Stage 1 Road Safety Audit Designer's Response

Report Title:	Stage 1 Road Safety Audit Designer's Response – Proposed Site Access, Hemingfield Road, Hemingfield
Date:	21 st August 2024
Document Reference and Revision:	23-160-006.03
Prepared by:	Bryan G Hall Limited
On behalf of:	Barnsley Metropolitan Borough Council (Overseeing Organisation)

Drawing No: 23/160/ACC/001

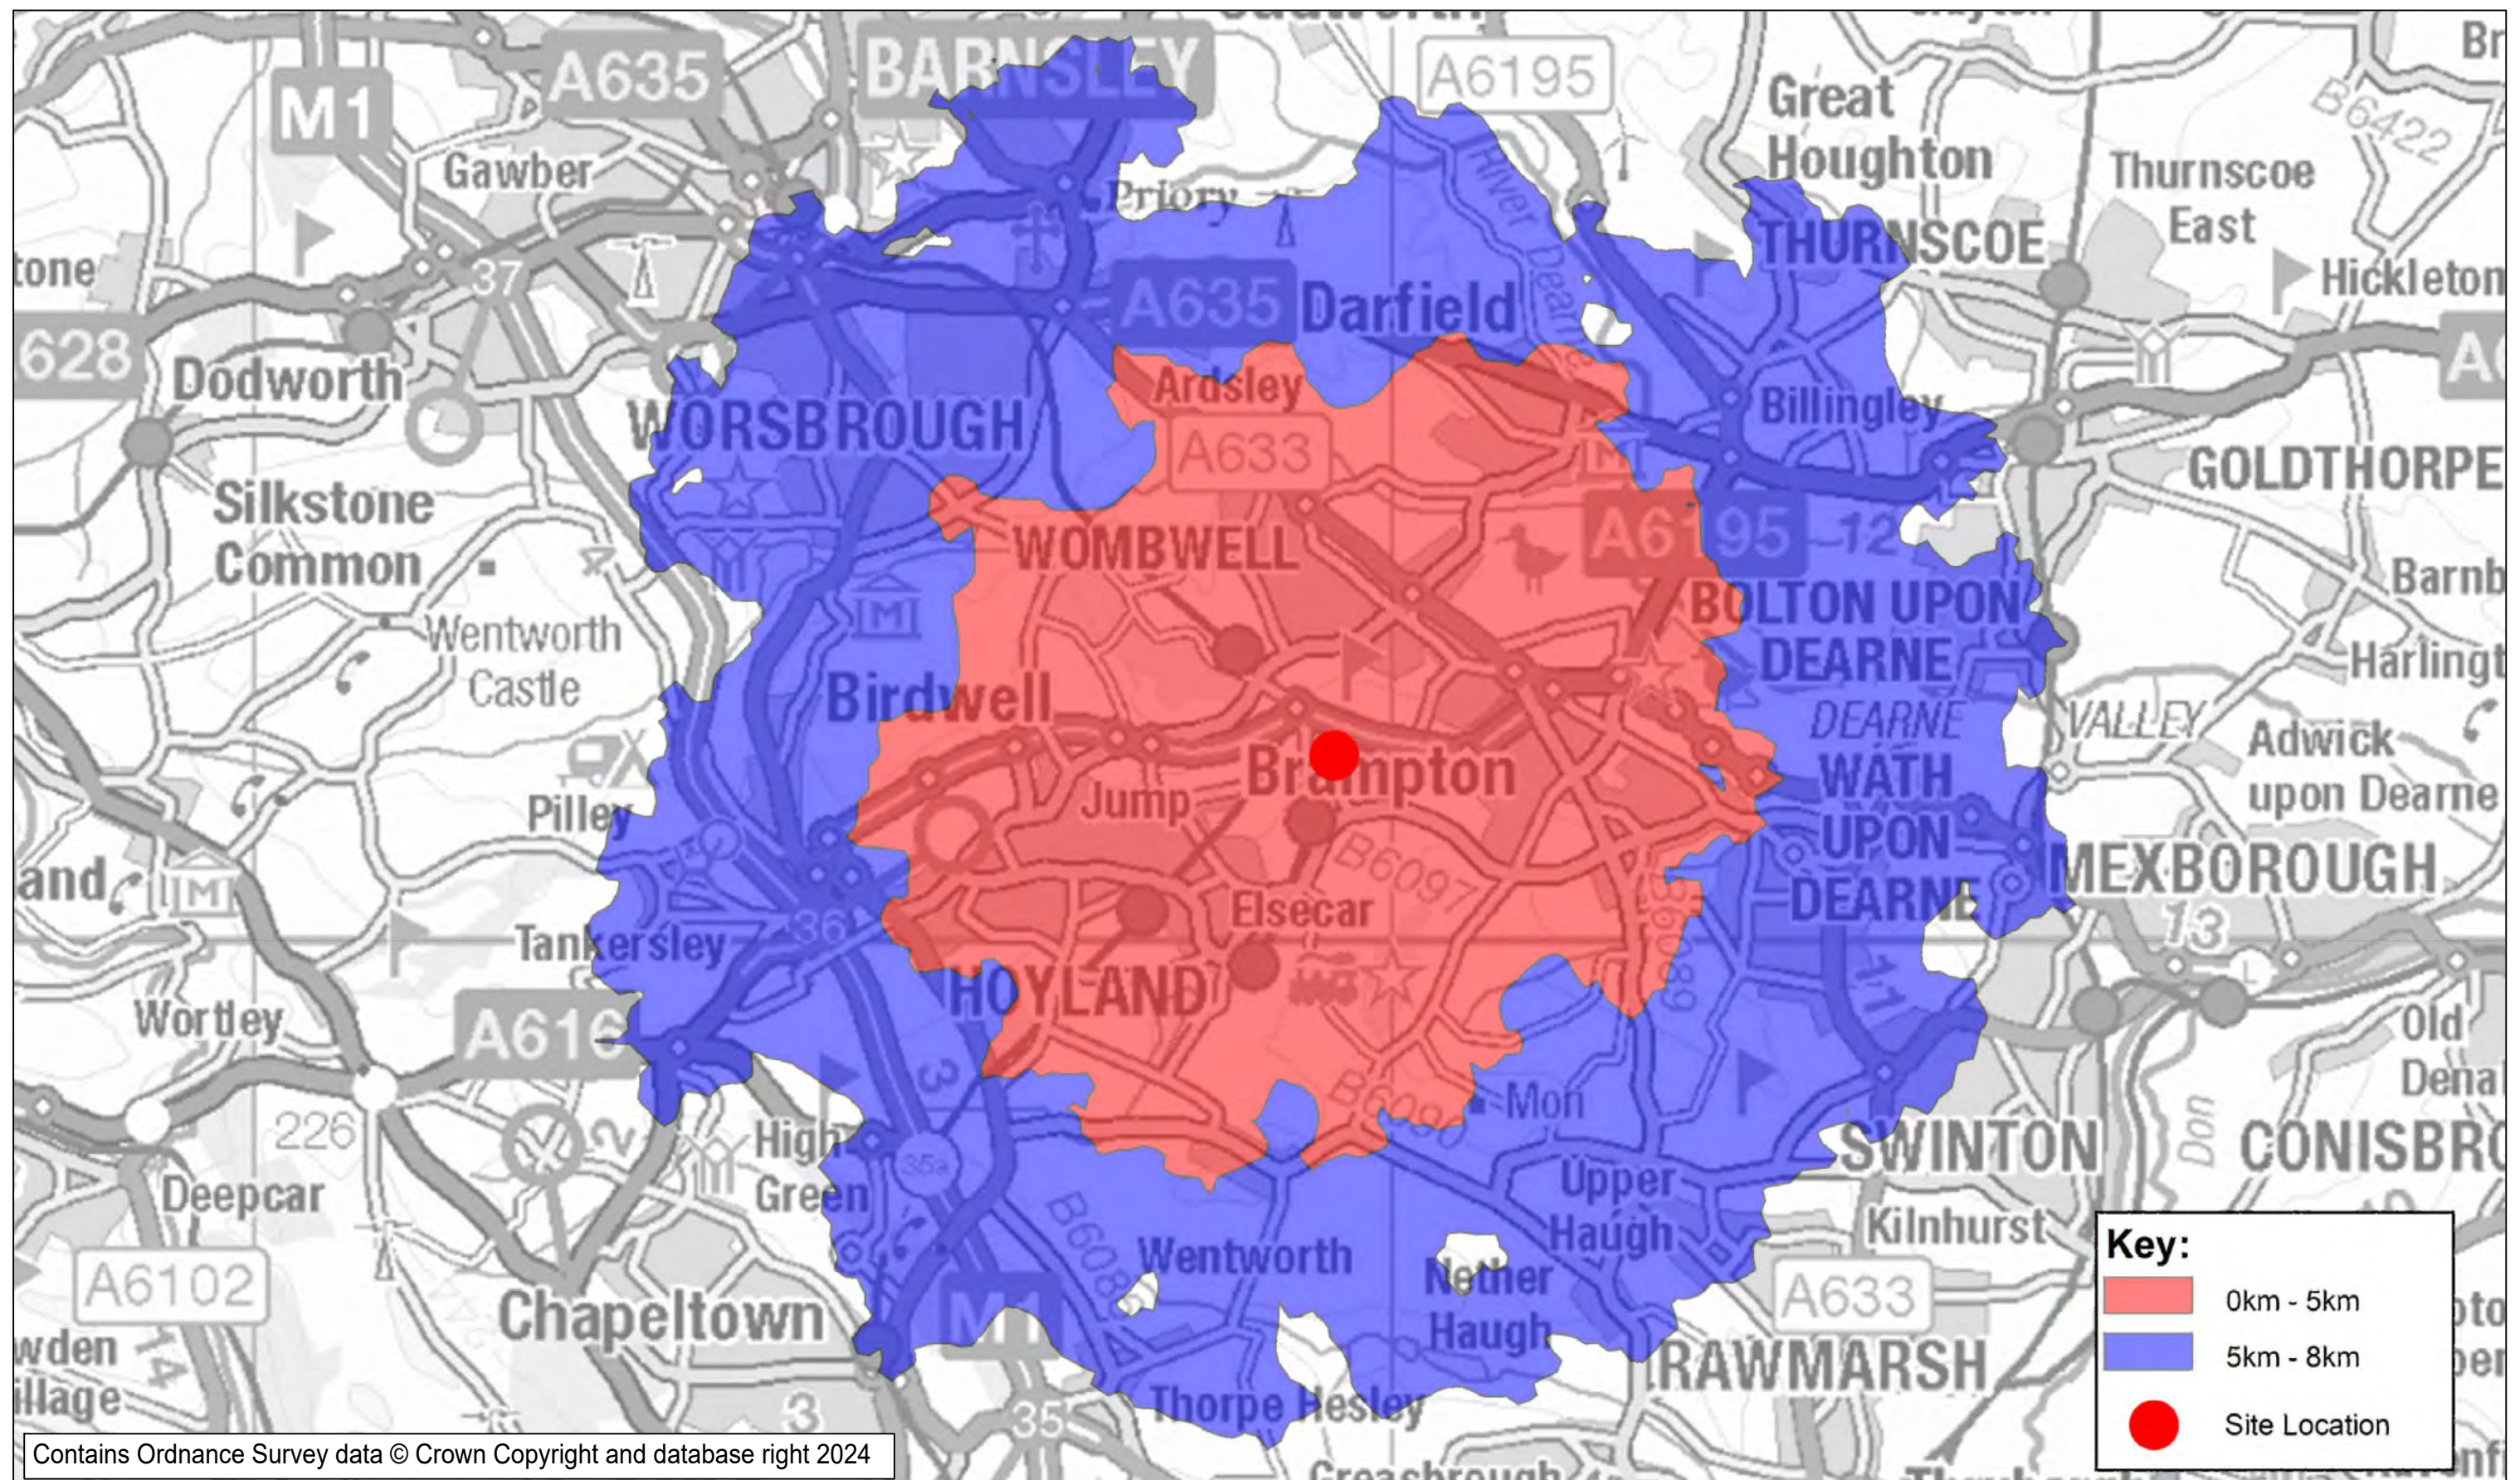
RSA Problem	RSA Recommendation	Design Organisation Response	Overseeing Organisation Response	Agreed RSA Action
Problem A				
Parking on western side of Hemingfield Road opposite the proposed site access.	It is recommended that measures to ensure that parking does not restrict carriageway width opposite the proposed side road are provided.	<p>Paragraph 5.9 of the Transport Assessment (document ref. 23-160-001.03) sets out that a 4 metre wide northbound through lane is proposed to accommodate the existing on street parking on Hemingfield Road in the vicinity of the proposed site access junction. This, alongside the provision of the 3 metre wide right turn ghost island means that traffic can continue to flow while vehicles are waiting to turn right into the site.</p> <p>Should vehicles be parked fully within the carriageway, this would require 2 metres of carriageway width, in line with the guidance in Figure 8.18 of Manual for Streets for parallel parking spaces. When combined with the proposed 3 metre wide right turn ghost island, there would therefore be an available width of around 5 metres for a car waiting to turn right into the site and a northbound car to pass through. It has been observed on site that vehicles currently park partially on the footway, therefore the available width may even be more than 5 metres.</p> <p>Figure 7.1 of Manual for Streets indicates that a minimum carriageway width of 4.1 metres is wide enough for two cars to pass each other, therefore a width of 5 metres is considered to be appropriate to accommodate a car waiting to turn right and a northbound car passing through.</p> <p>Figure 7.1 of Manual for Streets indicates that a minimum carriageway width of 4.8 metres is wide enough for a car and a larger rigid vehicle to pass each other. Therefore it may also be possible for a northbound refuse vehicle or a bus to pass a car waiting to turn right into the site. If not,</p>	Accept DO response

Problem C				
Footway provision on Hemingfield Road to the north of the proposed access.	It is recommended that tactile paving and dropped kerbs are provided at a suitable location to the north of the proposed access and that appropriate intervisibility is provided between the crossing location and oncoming vehicles.	<p>The proposed site access drawing has been amended to extend the proposed footway on the eastern side of the carriageway to the north for around 45 metres. An uncontrolled pedestrian crossing point with dropped kerbs and tactile paving is then proposed to be located in the vicinity of numbers 86 and 88 Hemingfield Road, just to the south of the existing vehicular dropped crossing which provides access to the private driveways for number 84 and 86 Hemingfield Road.</p> <p>53 metres forward visibility will be provided for southbound vehicles on Hemingfield Road to see</p>	Accept DO response

Problem E				
Proposed bus stop relocation location on Hemingfield Road.	It is recommended that forward visibility between drivers on the southbound carriageway of Hemingfield Road and the relocated bus stop is reviewed and measures are provided to ensure that the visibility envelope remains clear of obstruction.	<p>The exact location of the relocated bus stop is to be agreed with BMBC and the local public transport operators.</p> <p>Table 5.1 of the Transport Assessment shows that the surveyed 85th percentile speeds for eastbound vehicles in the vicinity of the relocated bus stop is 28.3mph, which equates to a 39 metre stopping sight distance. The proposed site access drawing has been amended to show a red hatched area within the site behind the proposed footway on the inside of the bend. The red hatched area will need to be kept clear from any obstruction above 1.05m in height, in order to provide 39 metres forward visibility around the bend and towards the relocated bus stop.</p>	Accept DO response

Problem H				
Hemingfield Road southbound through lane width.	It is recommended the southbound movement through the junction is assessed further to ensure that large vehicles including buses can pass through	Swept path analysis of a single deck bus and a 16.5 metre articulated HGV travelling southbound along Hemingfield Road has been undertaken, as shown on drawing number 23/160/ATR/003 Rev A at Appendix BGH2 .	Accept DO response

RSA Problem	RSA Recommendation	Design Organisation Response	Overseeing Organisation Response	Agreed RSA Action
		<p>then the northbound vehicle would simply need to wait briefly for the right turning car to clear. The modelling of the proposed site access junction shows that there would be minimal delays to vehicles turning right into the site of around 6/7 seconds and that queuing of more than 1 vehicle is not likely to occur, therefore this is not considered to be an issue.</p> <p>Furthermore, at present, it is apparent that vehicles may have to encroach into the opposing carriageway to pass the parked vehicles. Therefore, it is considered that the proposed site access arrangement represents an improvement over the existing situation.</p>		
Problem B				
Hemingfield Road southbound approach to the proposed site access.	Provide sufficient stopping sight distance on approach to the proposed new junction from the north.	<p>In response to Problem C, a footway is now proposed to the north of the access, which will necessitate the removal of some vegetation in this area. Any remaining vegetation within the adopted highway is to be trimmed back as necessary to achieve the 2.4 metres x 53 metres visibility splay to the north.</p> <p>A note has been added to the proposed site access drawing to clarify this.</p>	Accept DO response

RSA Problem	RSA Recommendation	Design Organisation Response	Overseeing Organisation Response	Agreed RSA Action
		<p>pedestrians on the eastern side of the crossing at a point 0.5 metres back from the dropped kerb. The 53 metres stopping sight distance has been measured along the centre of the southbound carriageway. The existing trees and vegetation will be trimmed back as necessary to achieve this forward visibility.</p> <p>On the western side of the carriageway, the proposed crossing is located where existing dwellings have private driveways and some additional block paved space in front of the properties to park off the carriageway. Therefore crossing pedestrians are very unlikely to be masked by vehicles parked on Hemingfield Road.</p>		
Problem D				
Site access pedestrian crossing facilities	It is recommended that tactile paving and dropped kerbs are provided at a suitable location on the desire line across the minor arm of the proposed junction.	An uncontrolled pedestrian crossing with dropped kerbs and tactile paving will be provide at the proposed site access as suggested. The proposed site access has been amended to show this.	Accept DO response

RSA Problem	RSA Recommendation	Design Organisation Response	Overseeing Organisation Response	Agreed RSA Action
	the junction safely without encroaching on the right turn pocket associated with the proposed access.	<p>BMBC have requested that a 0.5 metre clearance from the kerb line is provided for swept path analysis, therefore this has been reflected.</p> <p>The swept path analysis shows that both vehicles can pass southbound through the proposed junction without encroaching into the area of the right turn ghost island where vehicles may be waiting to turn right into the site. Whilst there is a very slight encroachment into the entry side of the ghost island, this is exaggerated by the 0.5 metre kerb clearance shown on the swept paths, as in reality, vehicles would be travelling more centrally within the southbound lane.</p> <p>Full height kerbs will be provided along Hemingfield Road, in the vicinity of the site access to provide added protection for pedestrians along the footway.</p>
